Consultation Response from: KC Environmental Health (Pollution & Noise Control)
2023/92935 27A-33 Commercial Street, Batley, WF17 5EP
Discharge of condition 6 (kitchen extraction) and 7 (prevention scheme) on previous permission 2020/94331 for change of use of retail unit to restaurant and alterations including balcony
**Responding Date:
20th November 2023**
**Responding Officer:
SR**
**Responding Ref:
WK202335584**
Comments

Condition 6 Odour Control – Kitchen Extract

Condition 7 - (prevention scheme)

title      Extraction flue component schematic

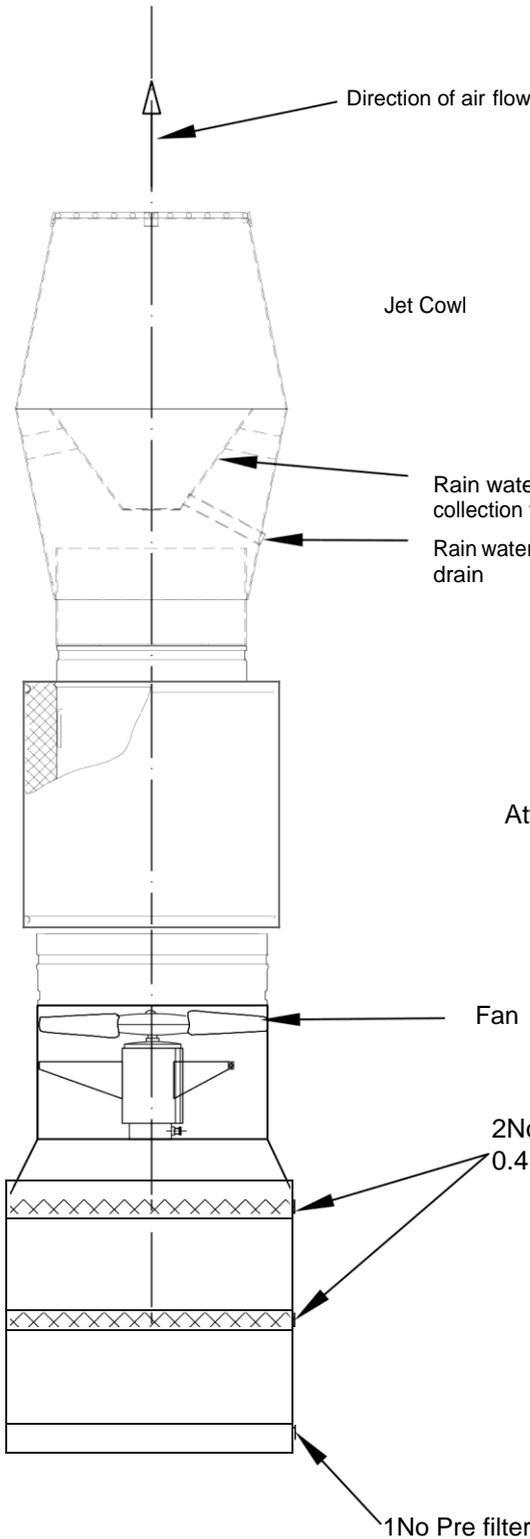
The risk assessment correctly identifies the need for a very high level of odour control at the premises and goes on to specify the necessary components that should be built into the extract system to achieve said odour control. We are concerned that the extract ventilation statement goes on to contradict the risk assessment in that it does not include all the required components of the extract system and offers a lower standard of odour control. The extract ventilation statement does not specify the exact height above the eaves of the terminus of the flue to the system, we require this in diagrammatic form.

Due to inconsistencies in the documents, we do not accept the information provided and make the following recommendation.

The submitted information does not meet with the requirements of the condition and therefore, we recommend the condition is not discharged at this time.
